RE: APD SE Area Command Center Project – Narrative

DRB Project Number: 1003450 Hearing Date: Feb 3, 2016  
 Project: 800 Louisiana Agenda Item No: (1)

**Subject:** Project # 1003450, Case # 15EPC-40029 – APD SE Area Command

TITLE: UTILITY PLAN

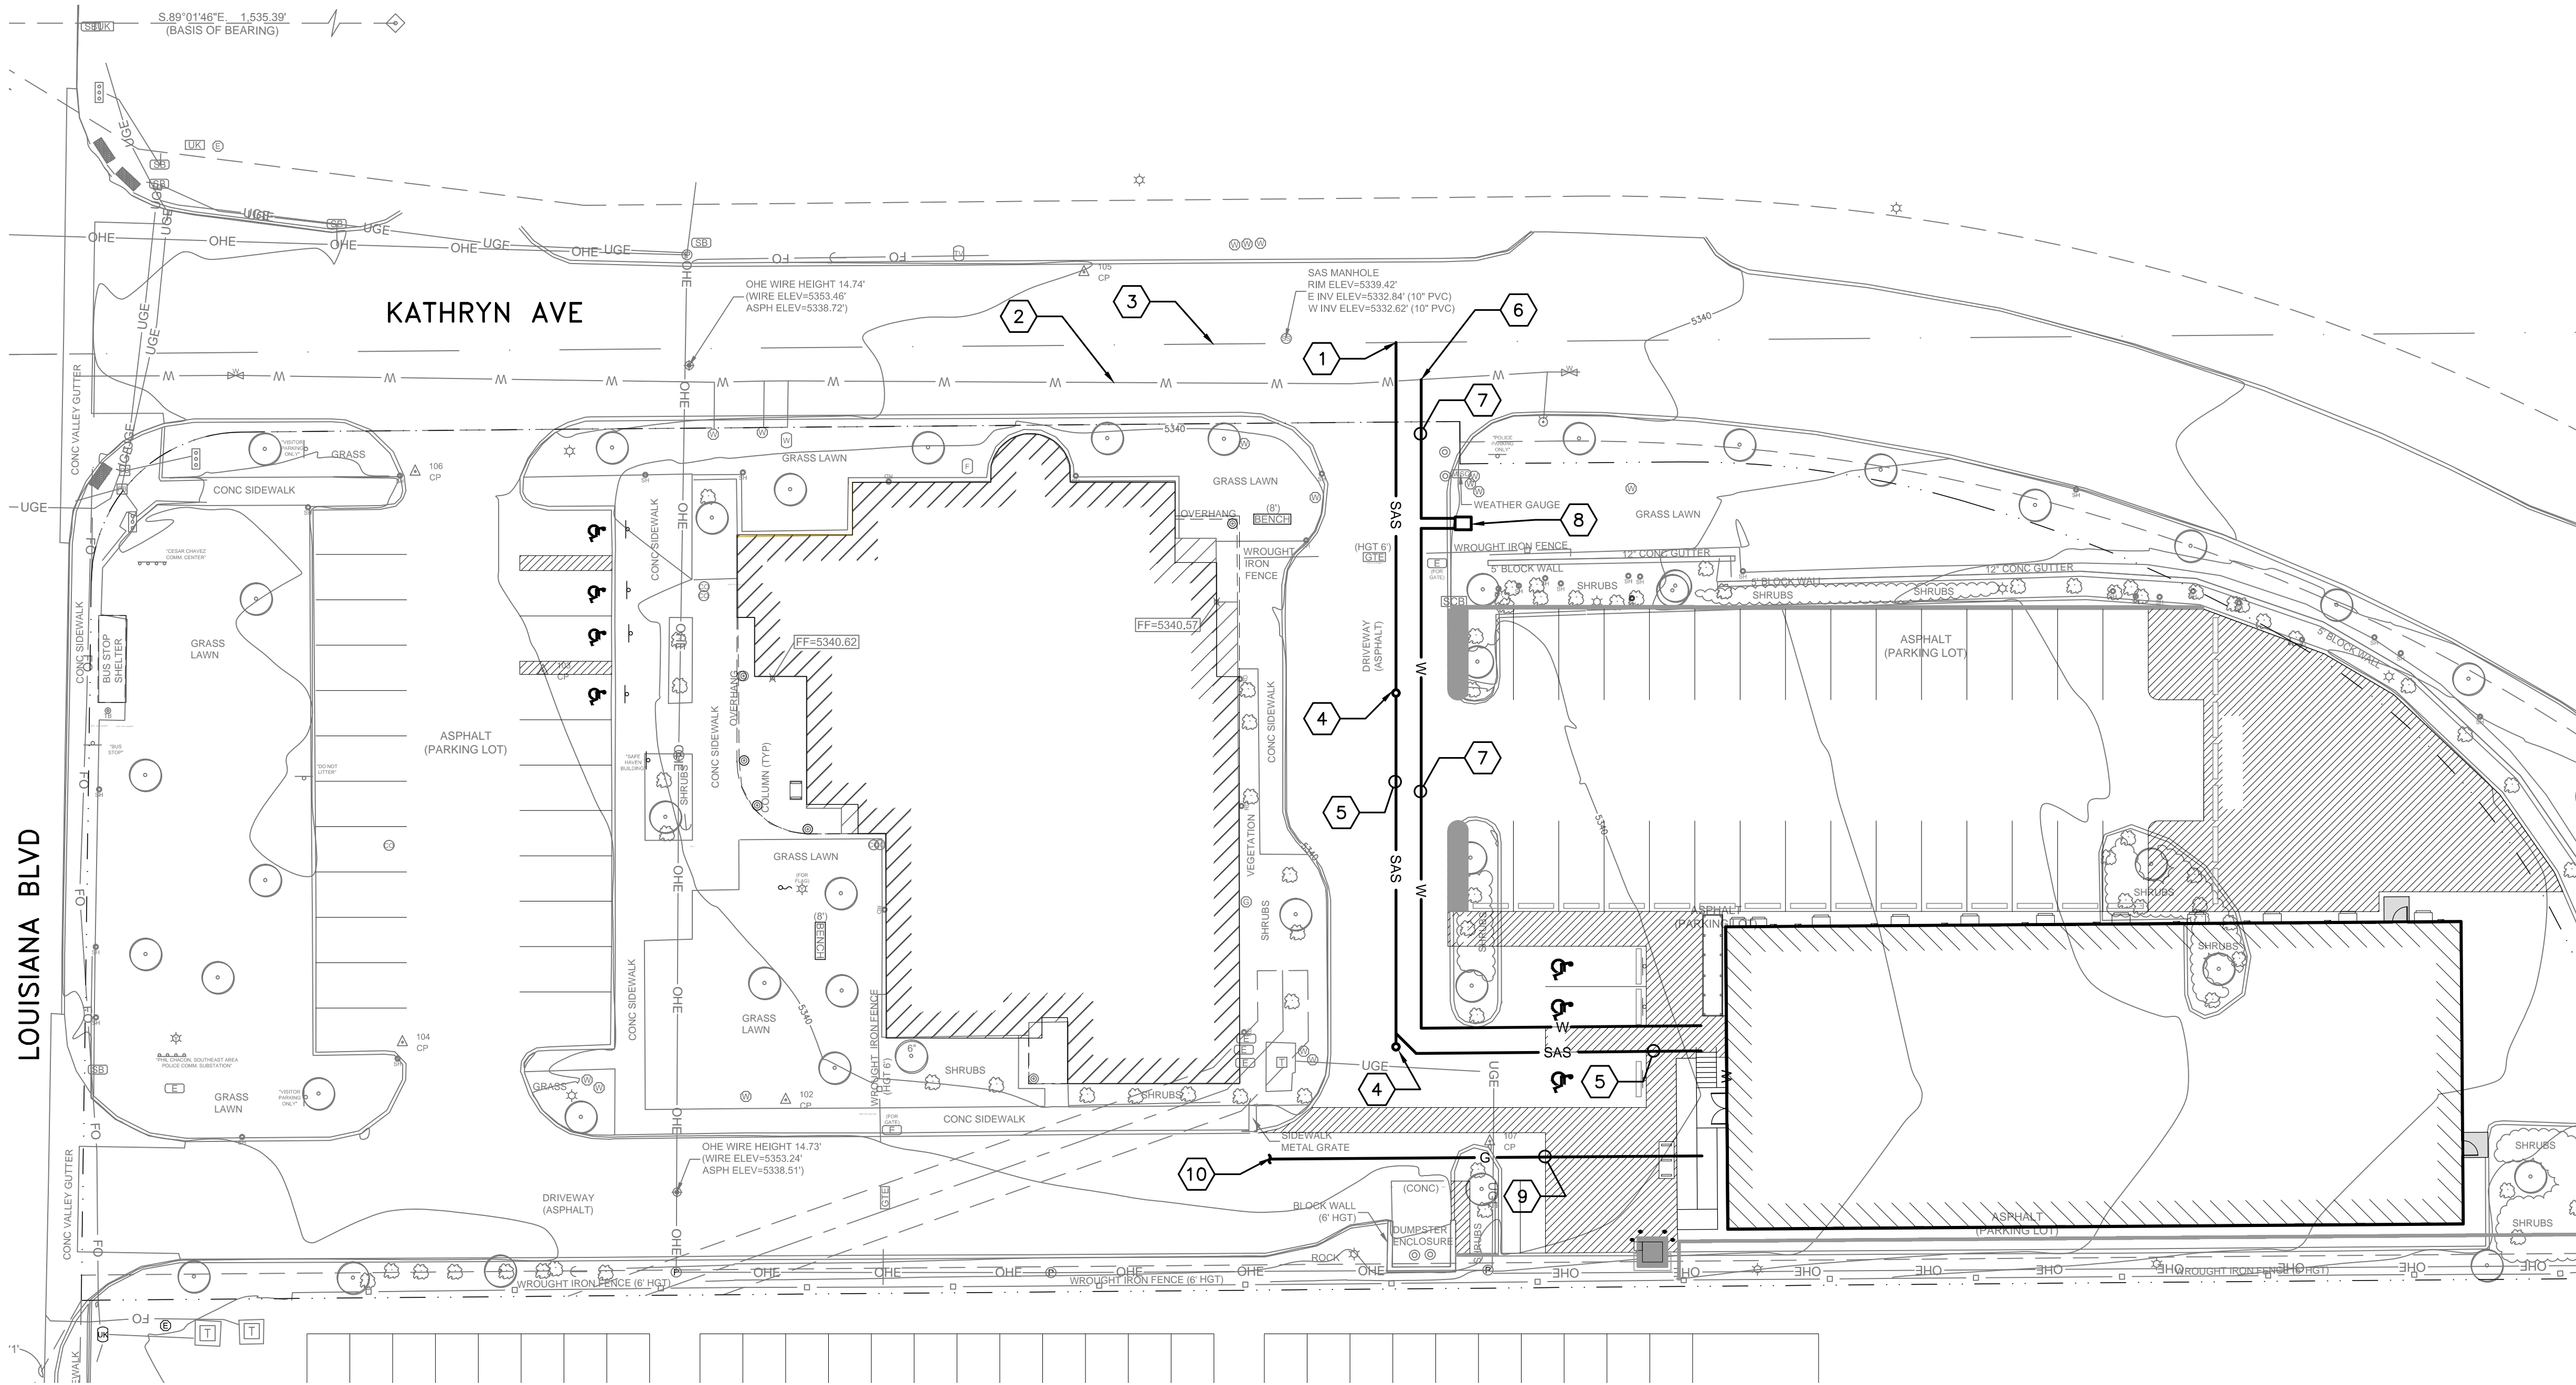
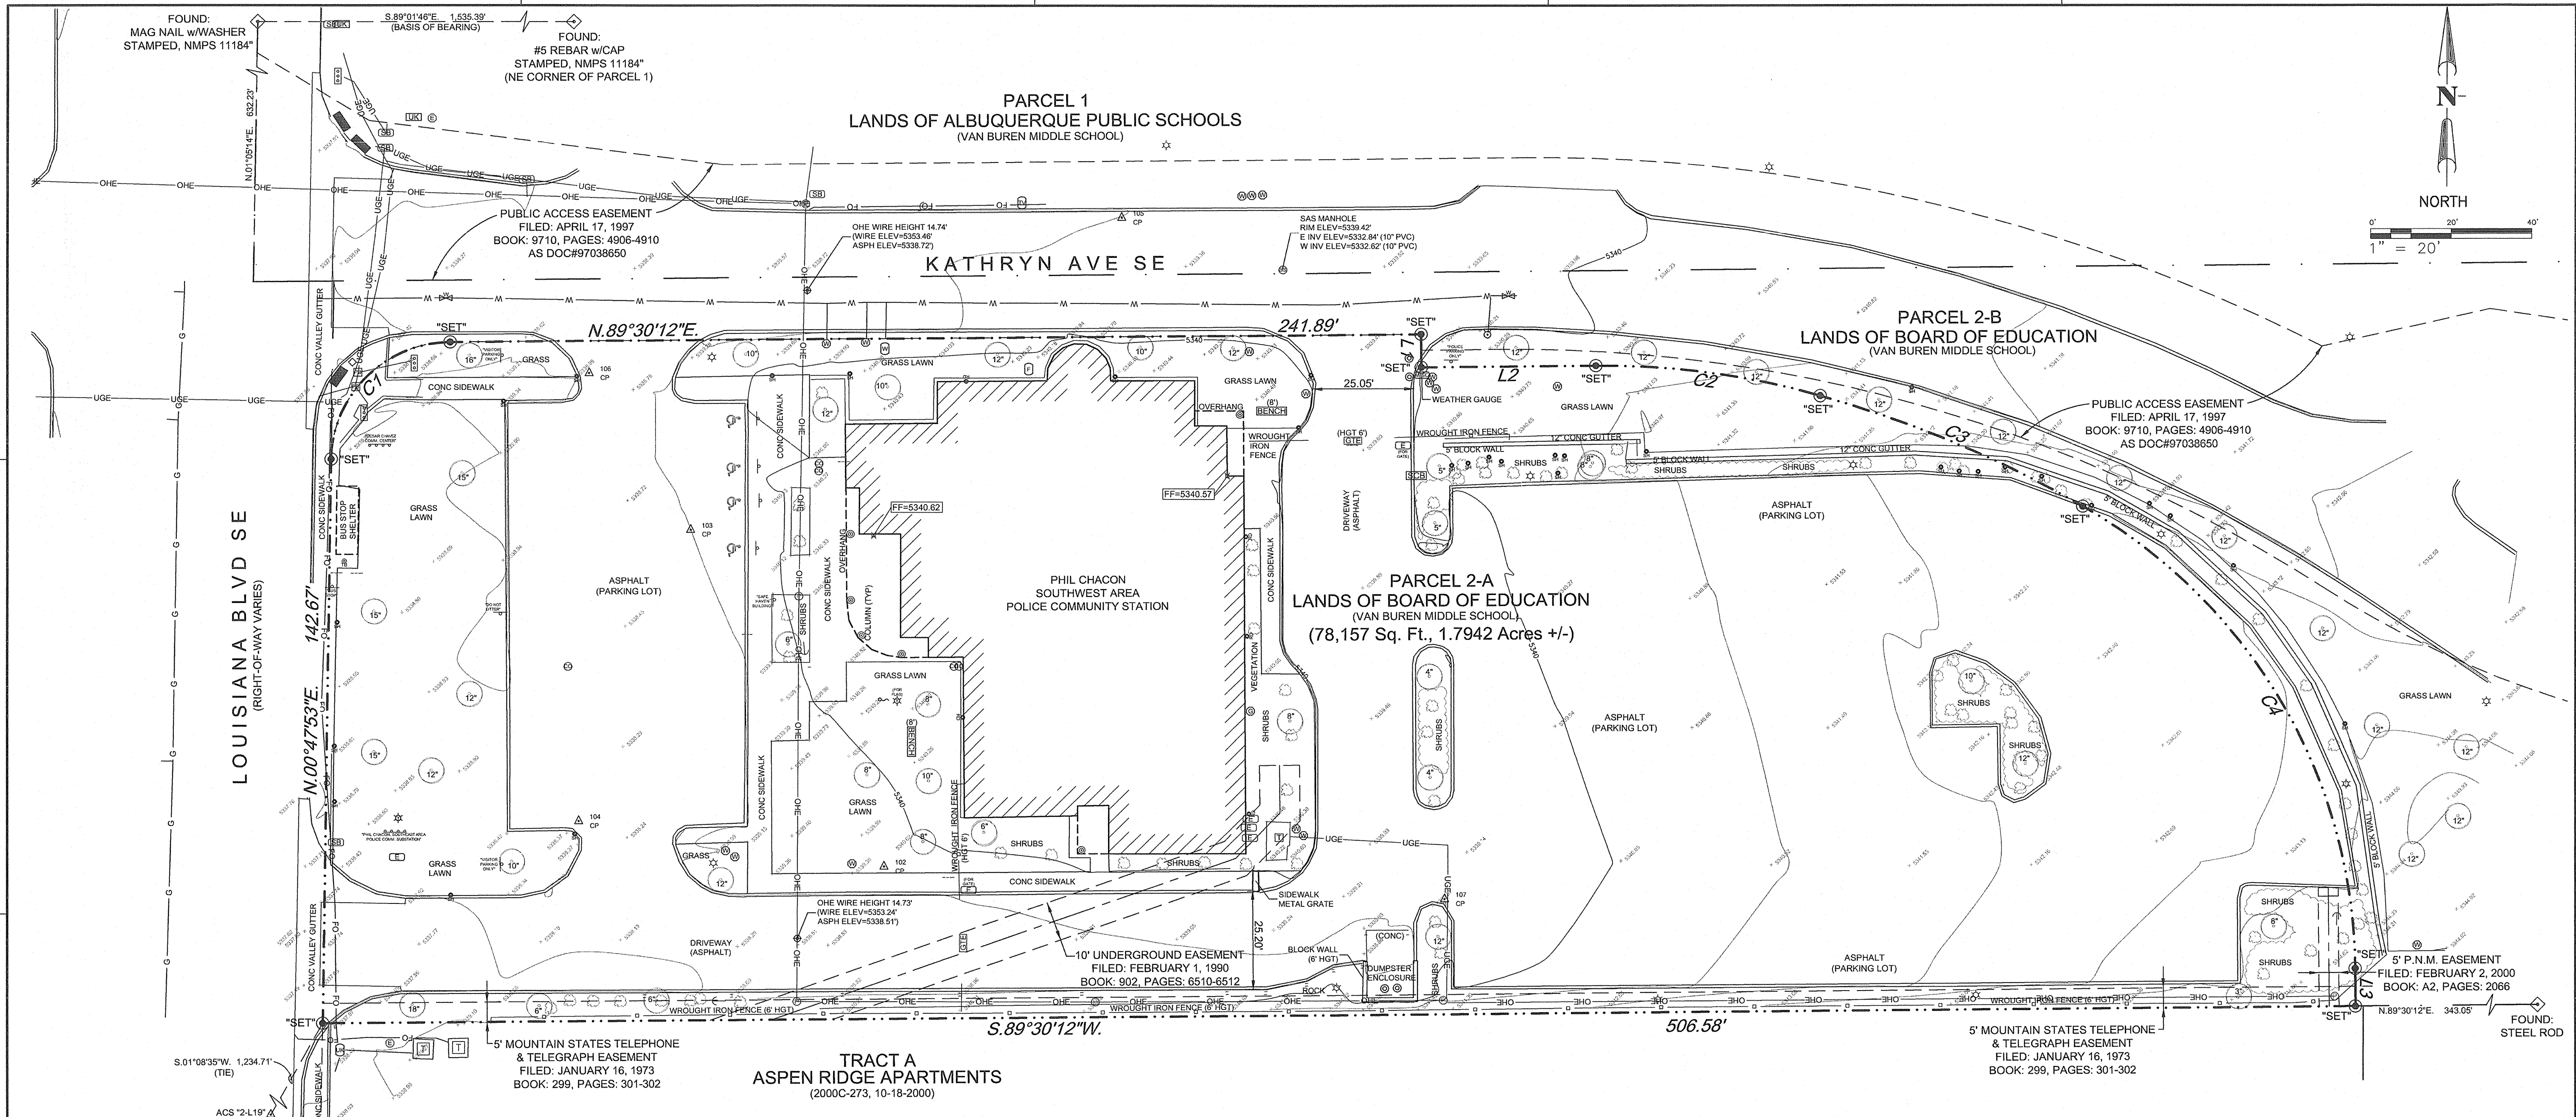
1. Request an availability/serviceability statement online at the following link: [http://www.abcwua.org/Availability\\_Statements.aspx](http://www.abcwua.org/Availability_Statements.aspx). Requests shall include fire marshal requirements. An executed statement must be obtained prior to approval.
2. Fire marshal stamp on the site plan did not include a required fire flow. This is needed to determine if the required fire flow can be met with existing waterline infrastructure.
3. Are new water and/or sanitary sewer services needed for this modular building or will it share the existing private services? Is a fire line going to be installed with this project?

1. The Accessibility/Serviceability Statement has been provided and included in this submission.
2. Fire Flow has been calculated and provided with this submission.
3. The Utility Plan included in this submission shows the Water and SS services provided. There will not be a fire line installed.
